Your Ref :
Our Ref : LU/112/18/NMA

Application for a non-material amendment following a grant of planning permission LU/252/17/HH relating to addition of 2No. Velux windows to proposed roof (one to north roof slope & one to south roof slope). Addition of cedar cladding to new rear gable at first floor level
51 Lansdowne Road, Littlehampton, ,

Elevations (1:100)

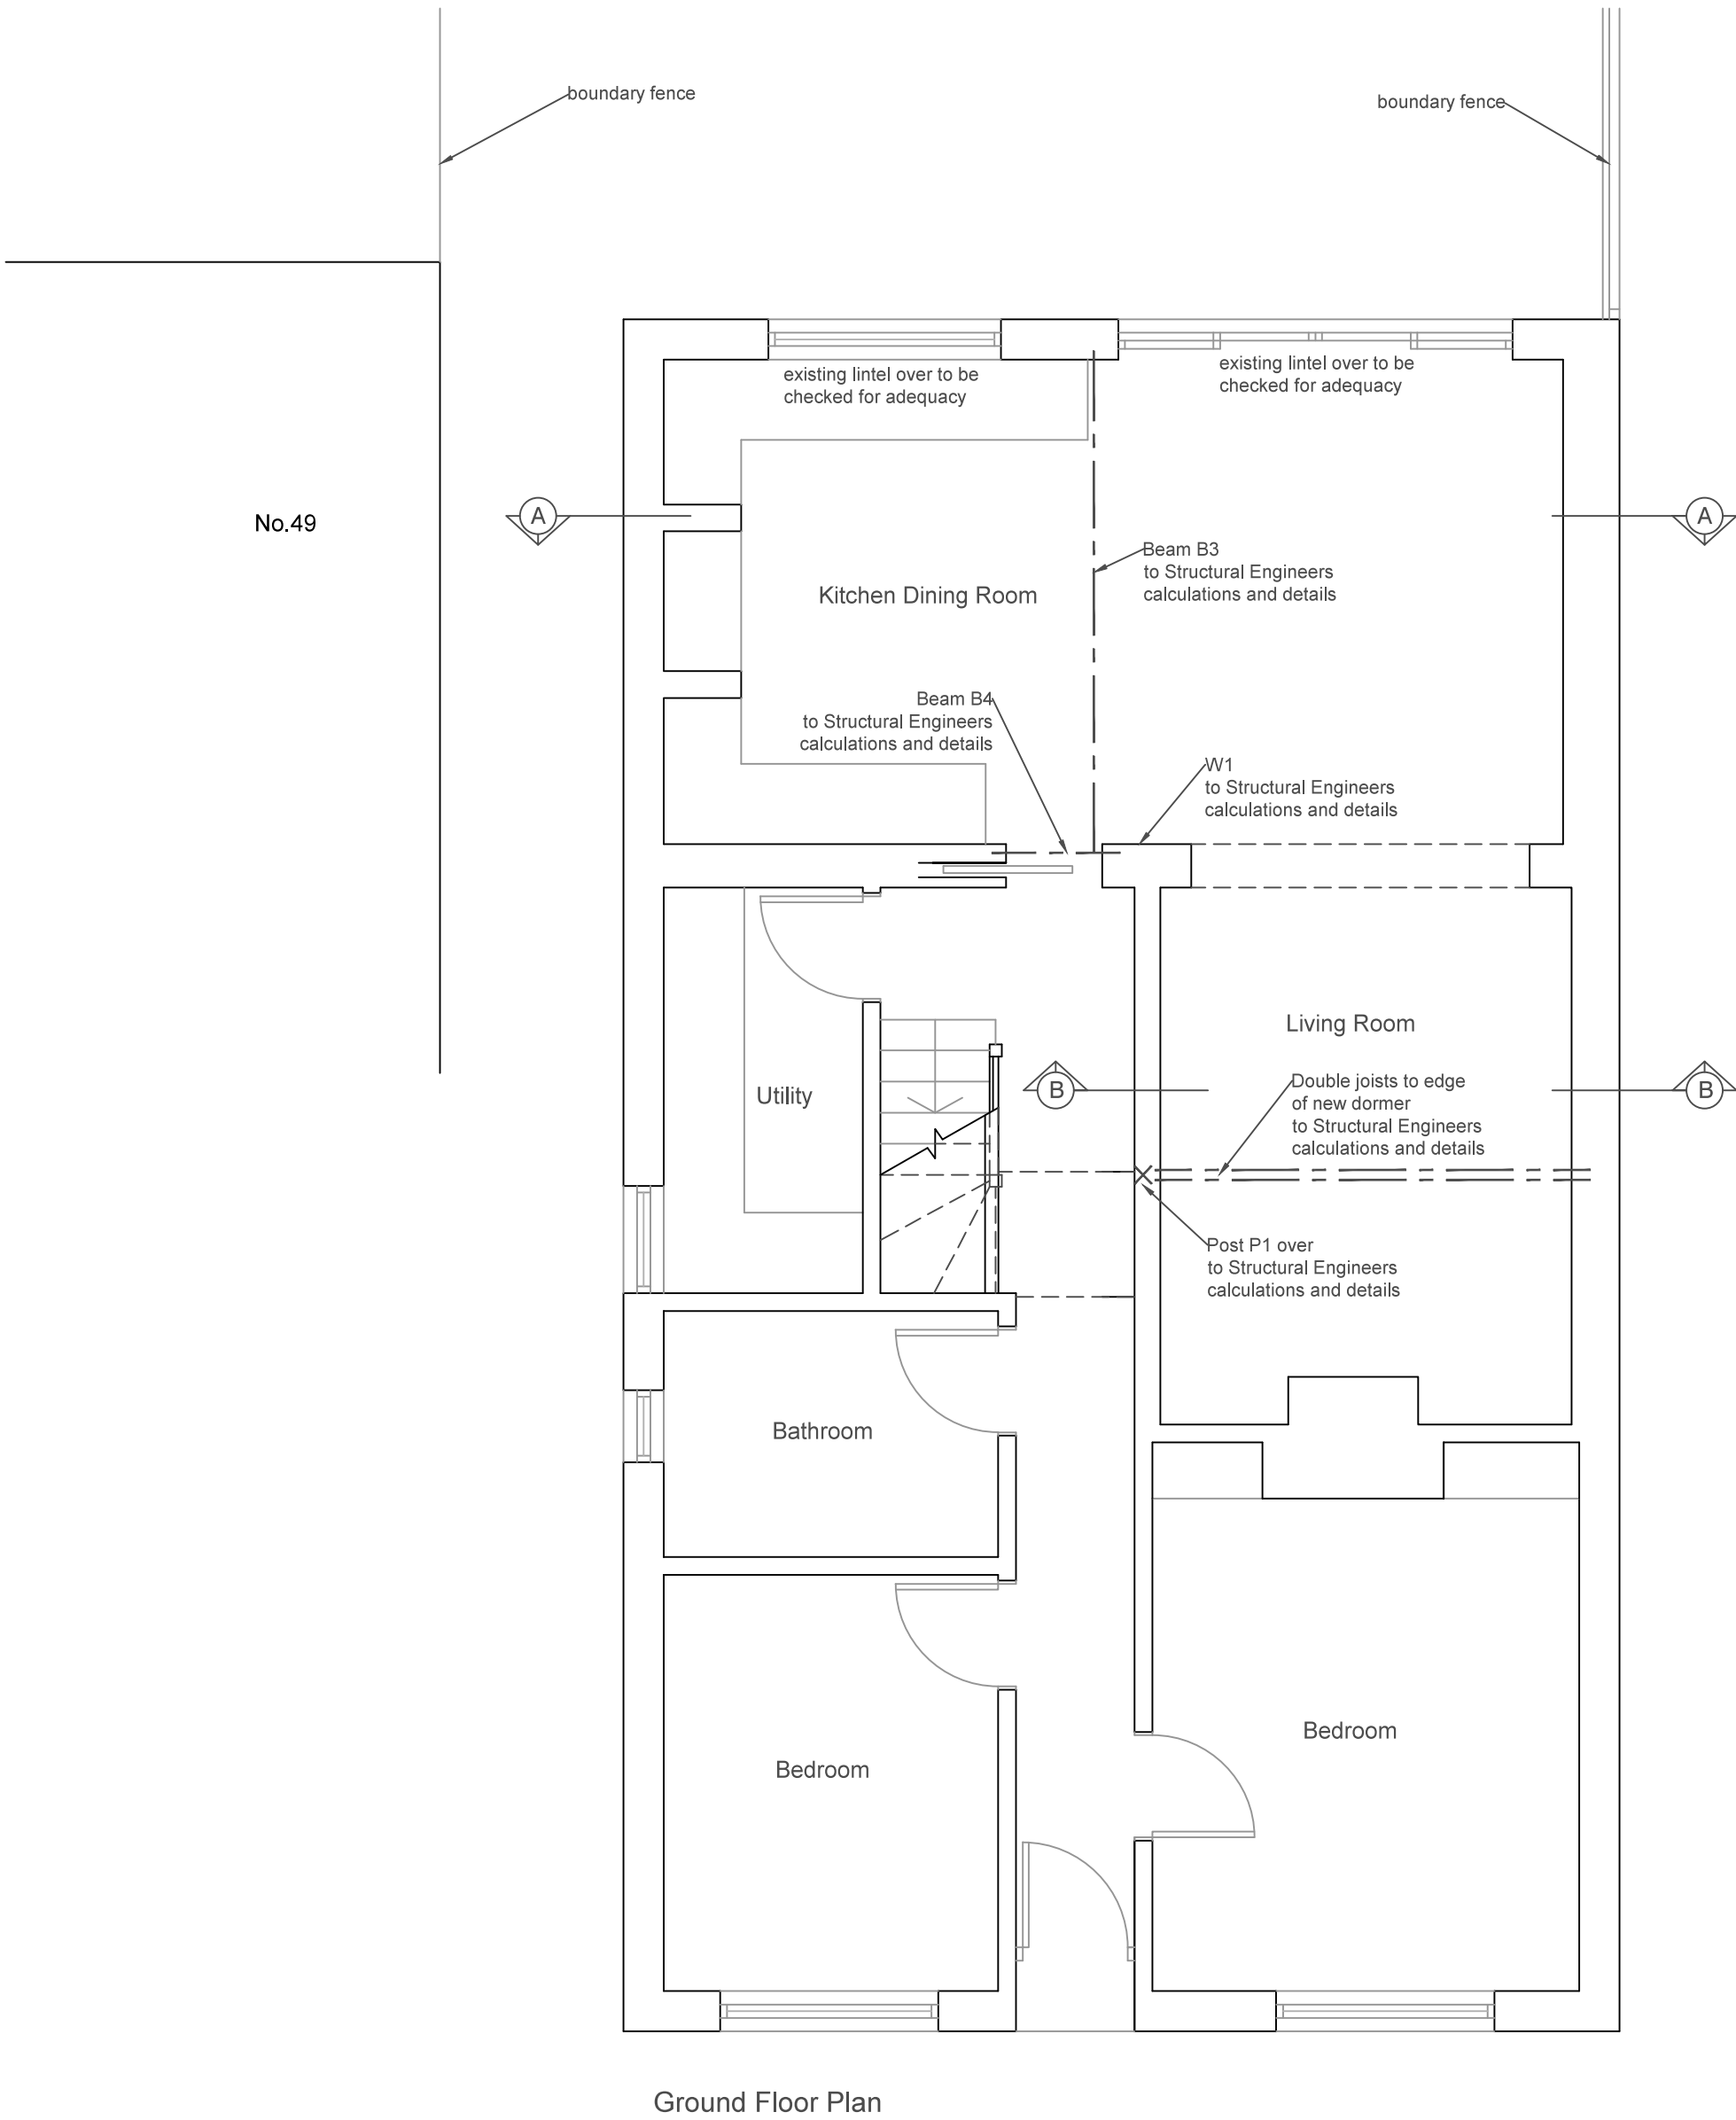
I refer to your recent application for a Non Material Minor Amendment. I note that you propose to add 2 roof lights, one on the north and one on the south elevation, and the provision of cladding to the rear gable.

The reasons that these proposals have been accepted as a Non-Material Amendment is because the changes do not materially alter the planning permission and do not necessitate additional consultation with local residents. It is noted that the new additional roof lights would face onto the site side boundaries, but the eill heights would prevent a material loss of privacy to neighbouring properties. The changes can therefore be considered as an NMA under section 96A of the Town and Country Planning Act 1990.

Please note that Drawing 1112.02.e "Proposed Plans and Elevations" has now become the approved plan for planning permission LU/112/17/HH.
